DRB Application No.: 08DRB-70491

Project Name: LAVALAND ADDITON

DRB Comments

RE: Lots 1 and 31, Block 4, Lavaland Addition

PLAT OF
 LOTS 1-A & 31-A, BLOCK U
 LAVALAND ADDITION
 PROJECTED SECTIONS 14, T. 10 N., R 2 E., N.M.P.M.
 TOWN OF ATRISCO GRANT
 CITY OF ALBUQUERQUE
 BERNALILLO COUNTY, NEW MEXICO
 OCTOBER 2008
 SHEET 2 OF 2

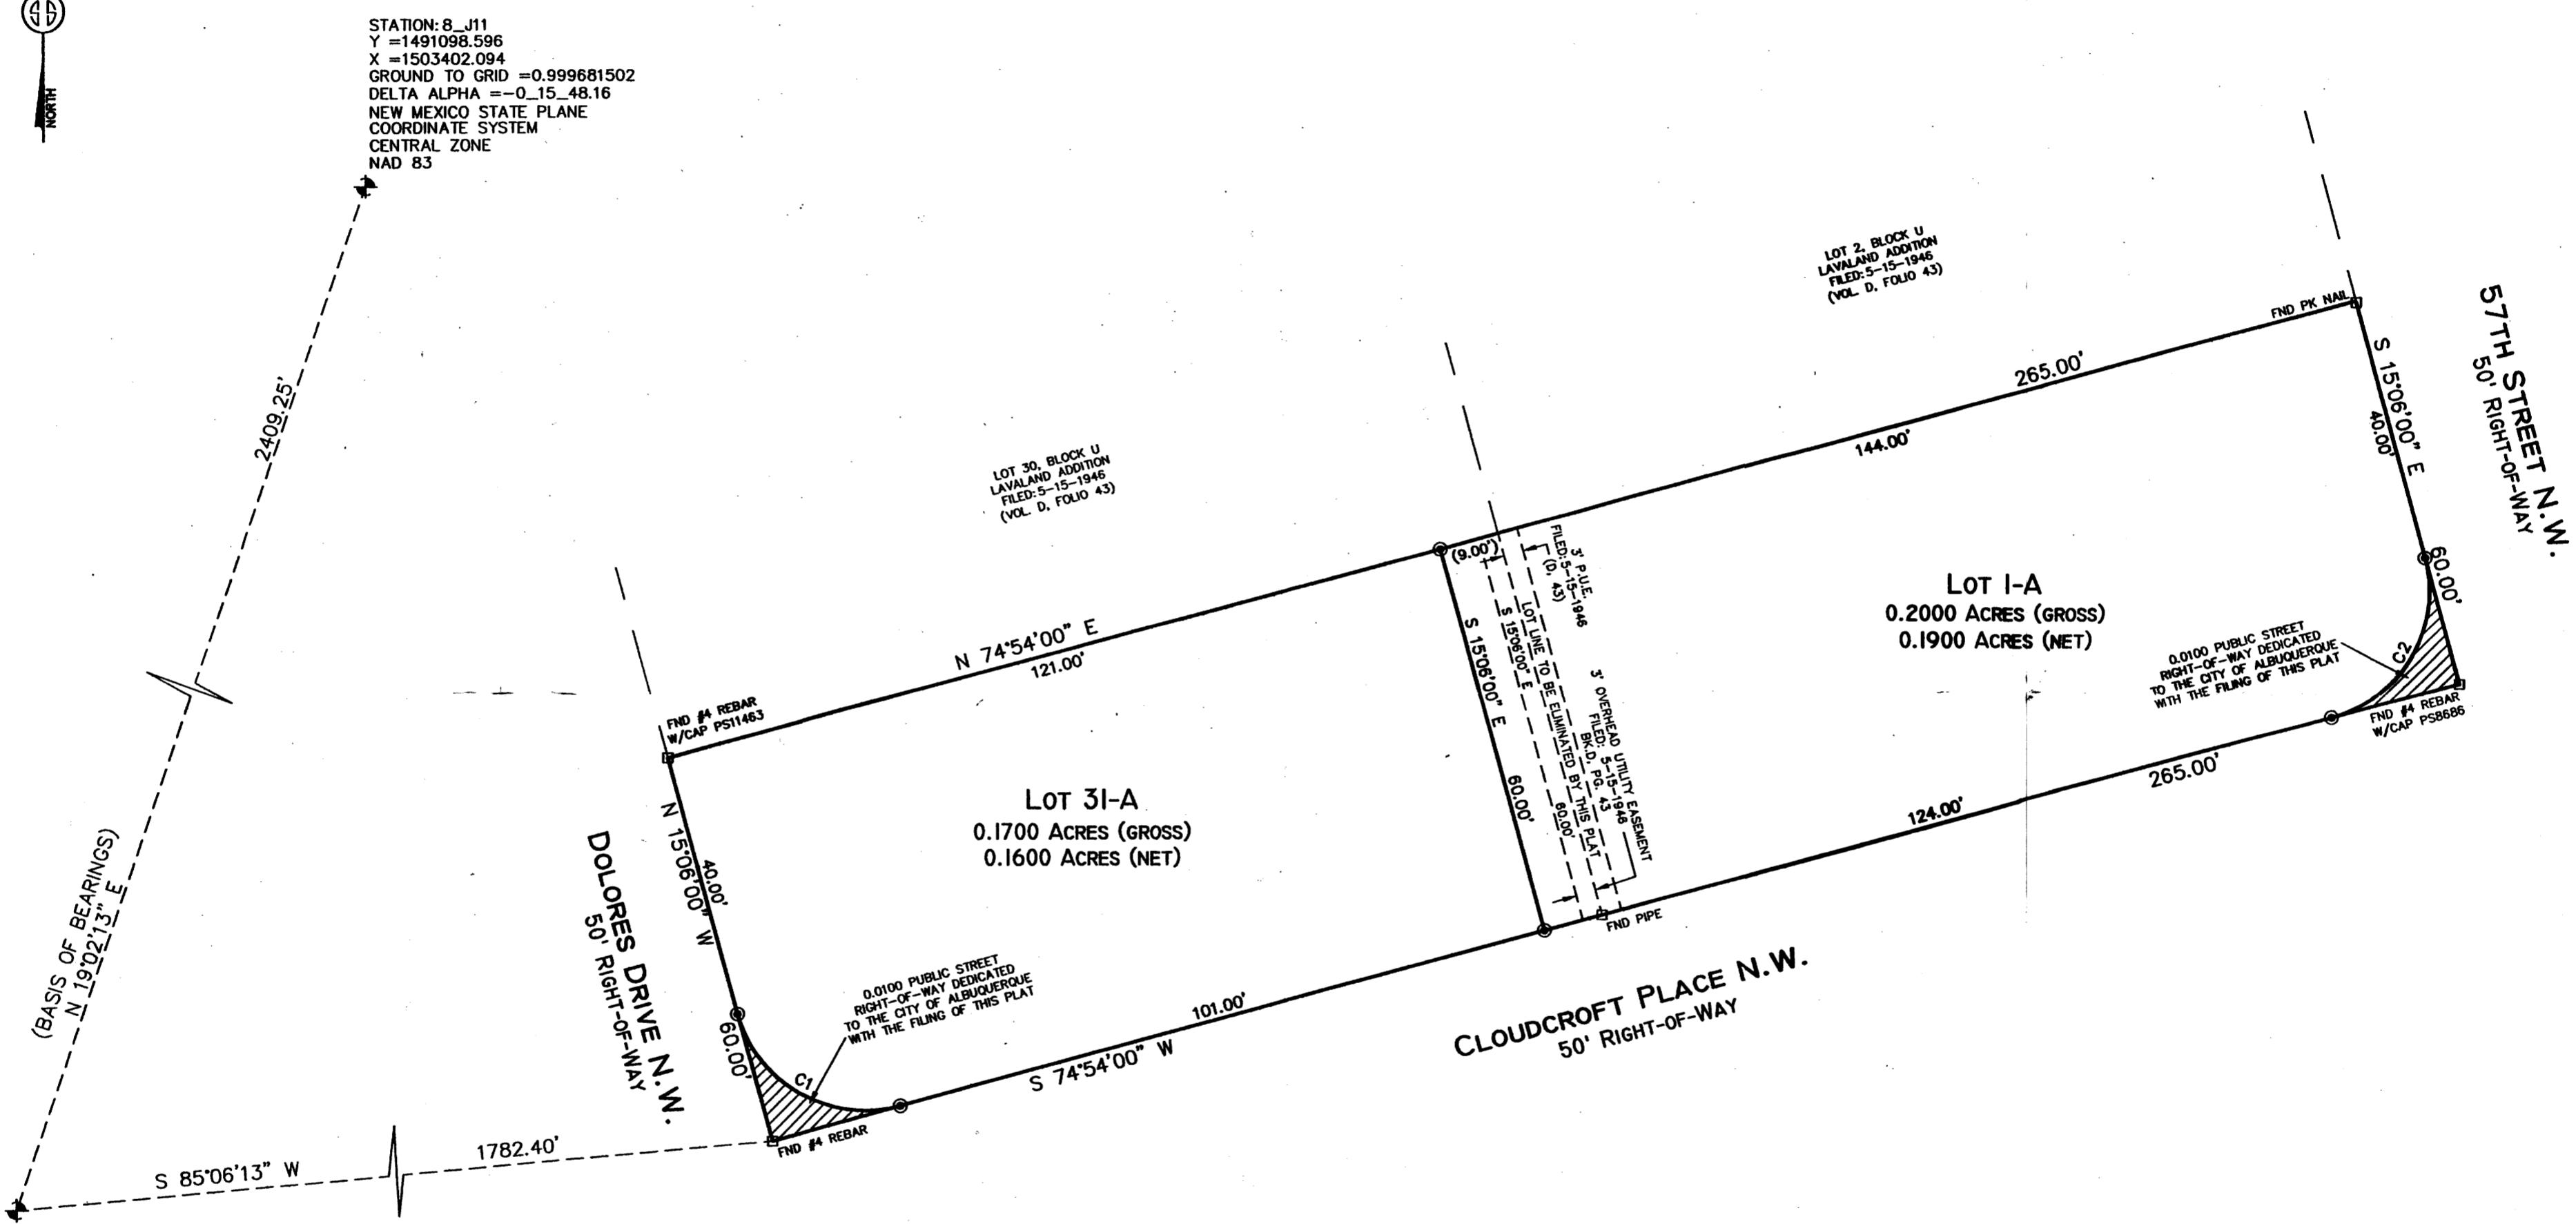
It appears Lot 31 would become deficient in required off-site parking with the proposed plat. Verification is needed from Zoning Enforcement that the driveway being moved from Lot 31 to Lot 1 is excess parking, and not required parking for the apartment on Lot 31, as well as verification of adequate remaining setback for Lot 31.
